Deadline 4 –

Written summary of oral submissions made at hearings w/c 1 November 2021

On behalf of Honingham Aktieselskab - A47 North Tuddenham to Easton Road Improvement Scheme

Scheme Reference: TR010038

SECTION 1

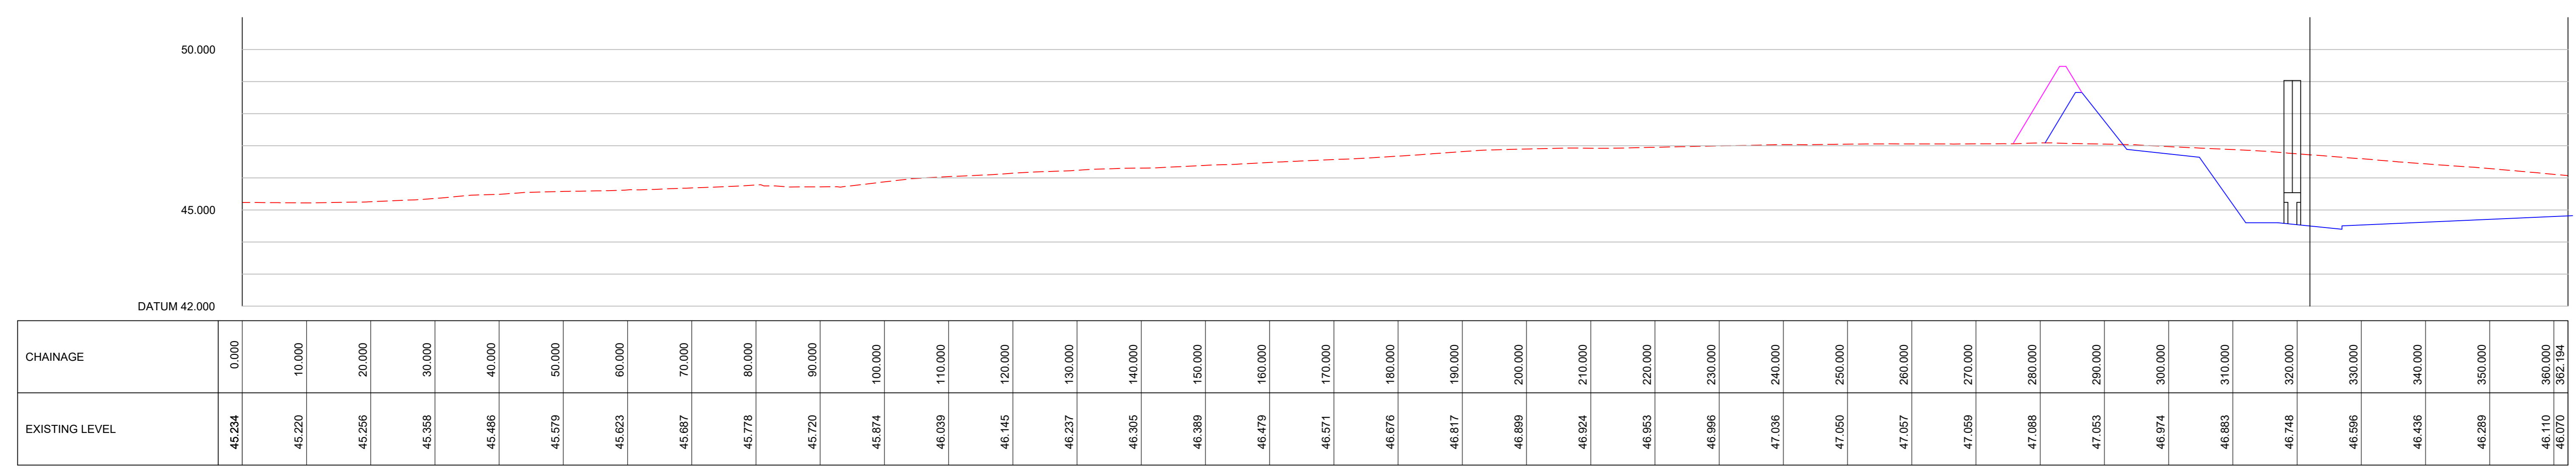
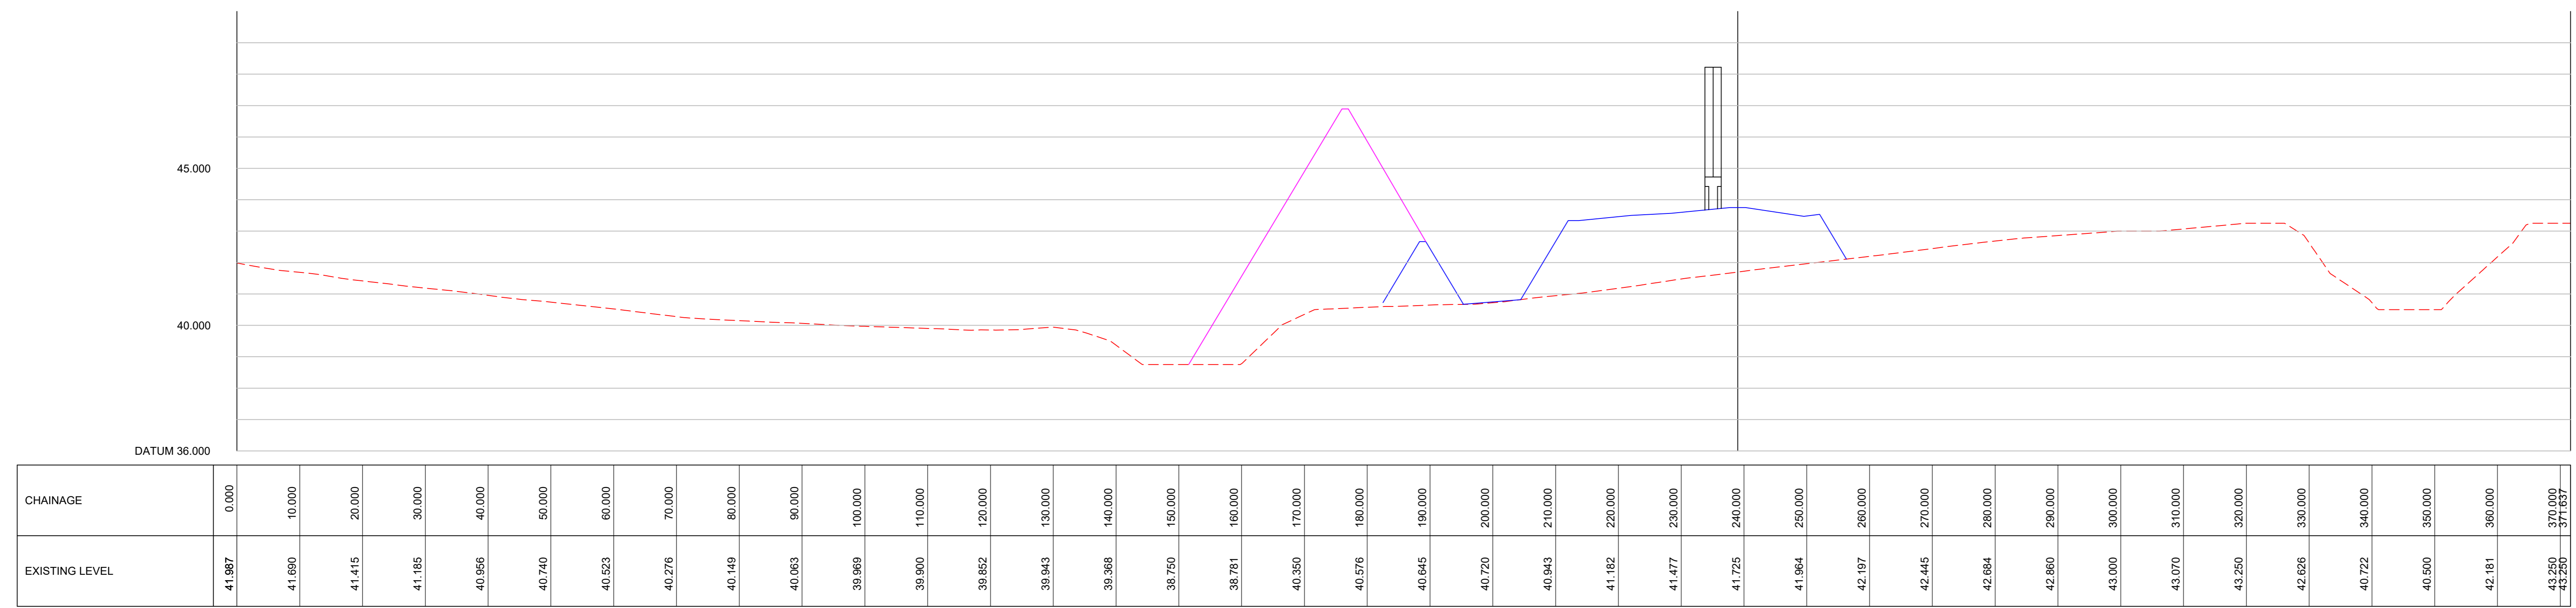
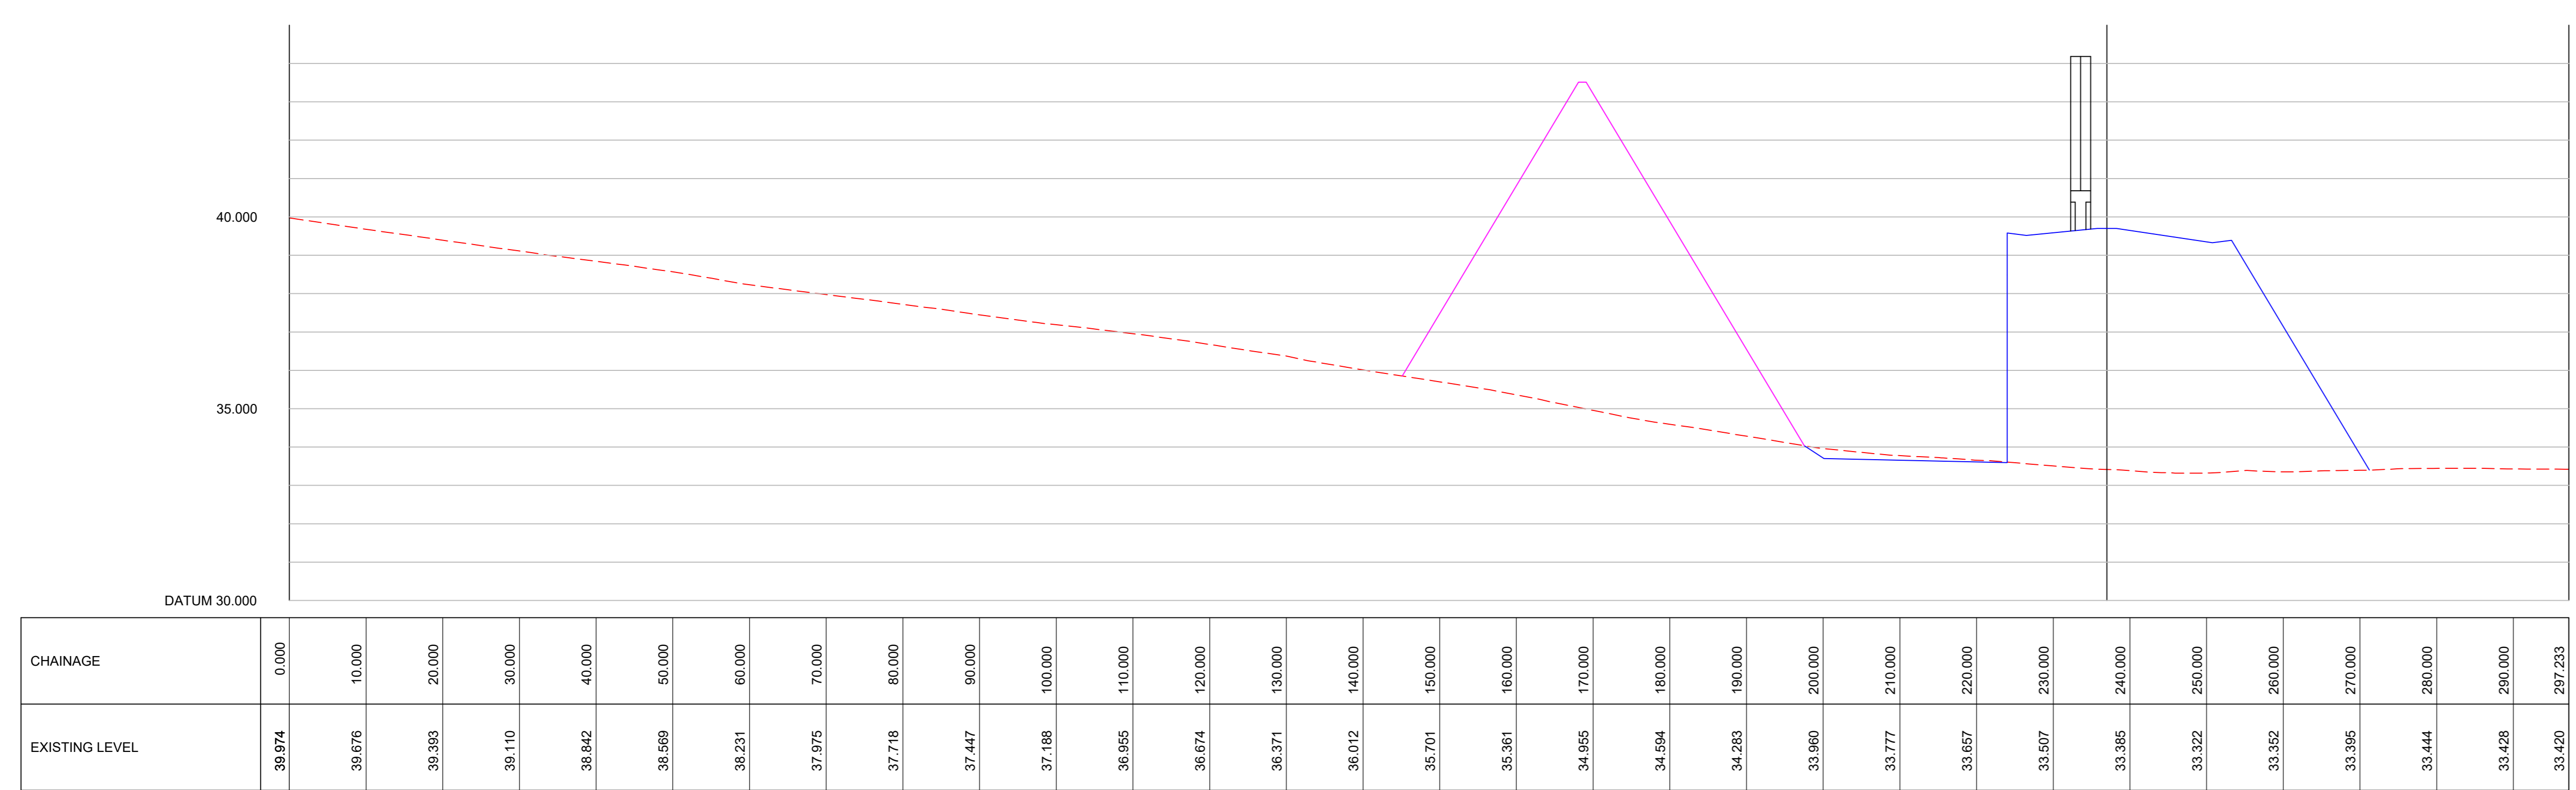
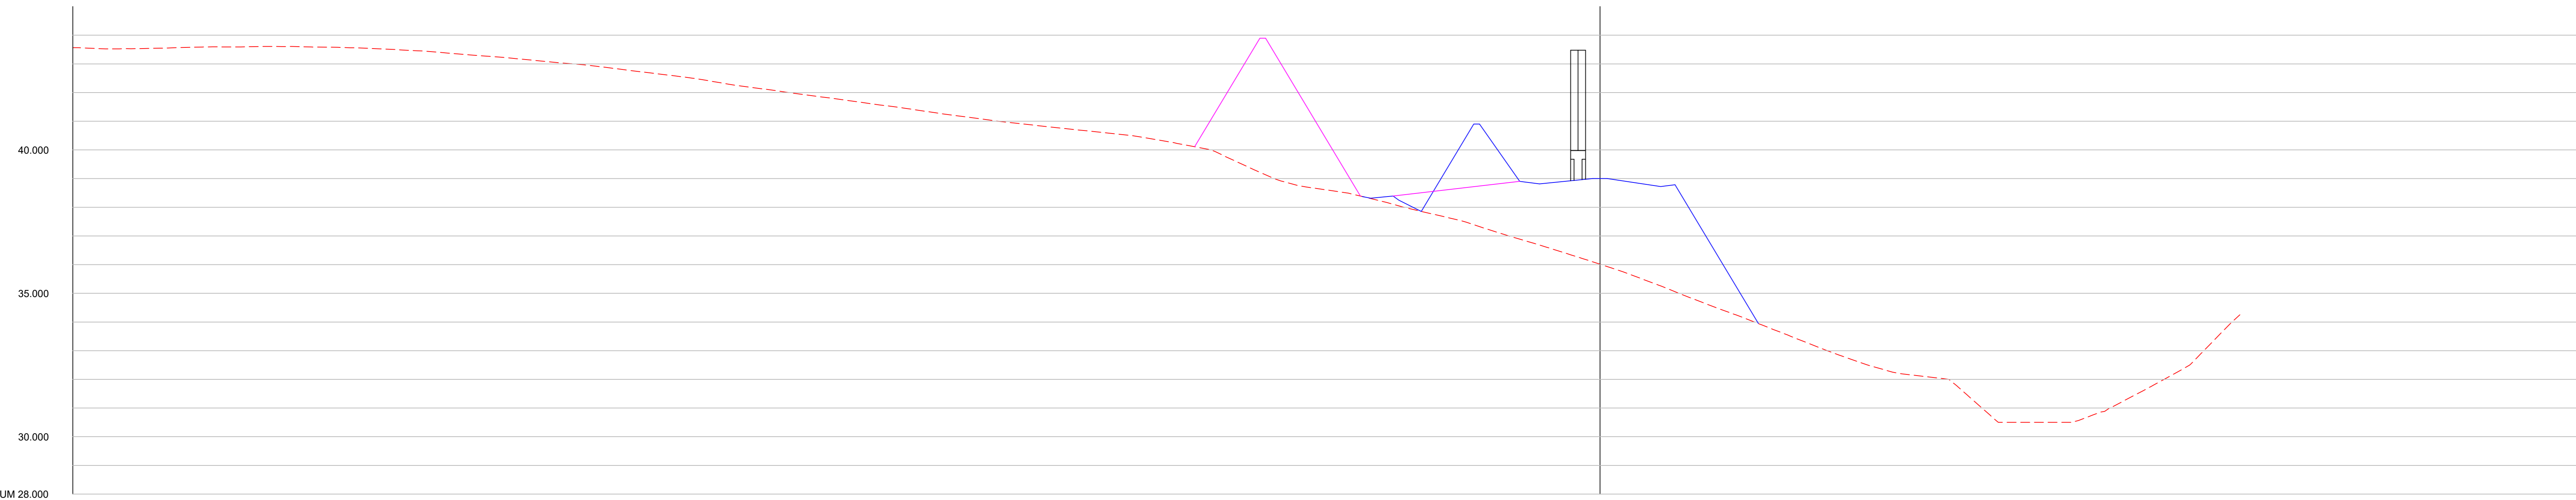
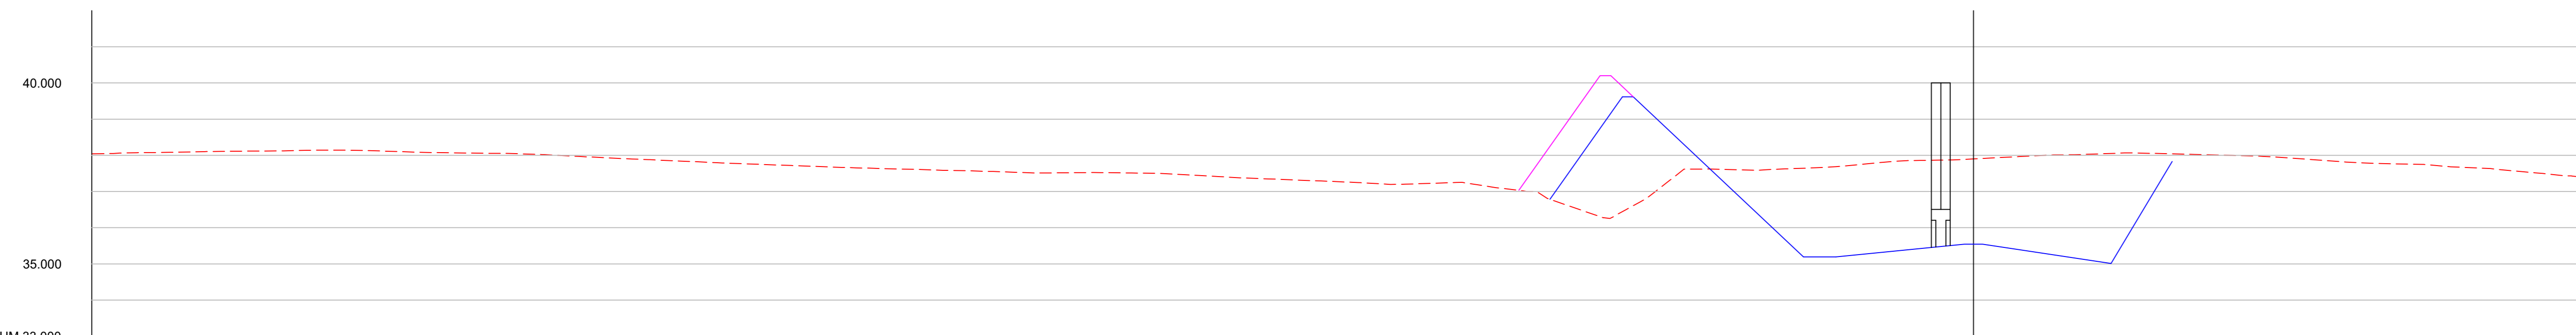
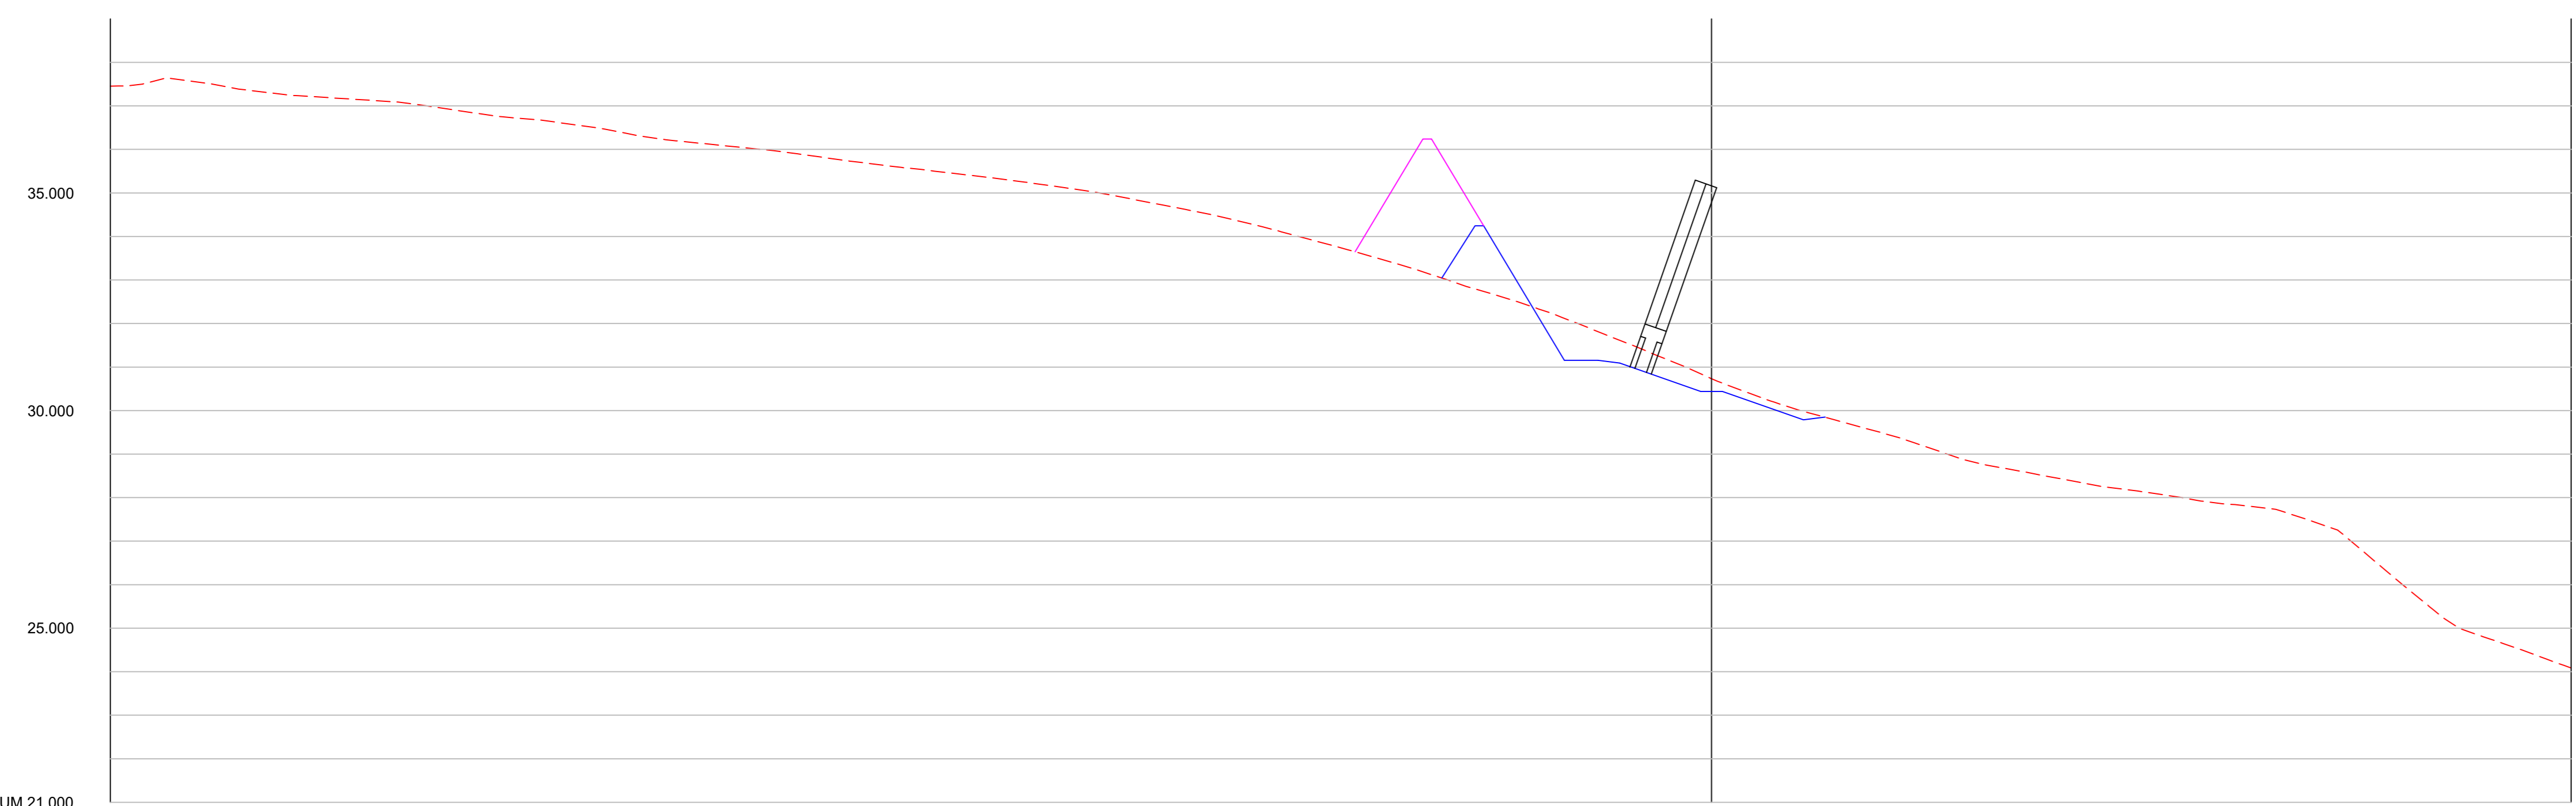
The drawings at REP3 – 030 to REP3 – 034 provide clear evidence that the scheme will impact on the retained land and the Applicant’s denigrating the vertical scale does not make the drawings incorrect nor does it prevent a meaningful discussion about the impact of further embankment which would be reviewed in the same vertical scale as the drawings.

The Applicant was critical of the owner's drawings presented at reference Rep 3-030 to 037 whereas in fact an exaggeration of the vertical scale doesn't make the drawings less plausible, it merely accentuates the image.

The height of the carriageway and the type of embankment required to mitigate the respective height of articulated lorries is displayed clearly with a vertical scale and with the greatest respect provides a far clearer image than the overlong horizontal scale long views presented by the Applicant.

In parts, relatively modest increases in the height of the embankment will have a significant impact. In other parts more significant works are required, more notably:

- i. from the Wood Lane junction eastwards to a point approximately to the east of the Hall Farm underpass and
- ii. as the road travels past Hall Farm towards the Tud Valley which can be best screened.

The former section near the Hall Farm underpass can be best screened with additional height bunding within the red line area where the owner is prepared to make land available.

The latter area towards the River Tud is best mitigated by extending the embankment on the north side of the wood and the attenuation lagoon at a higher level than to run is down alongside the road.
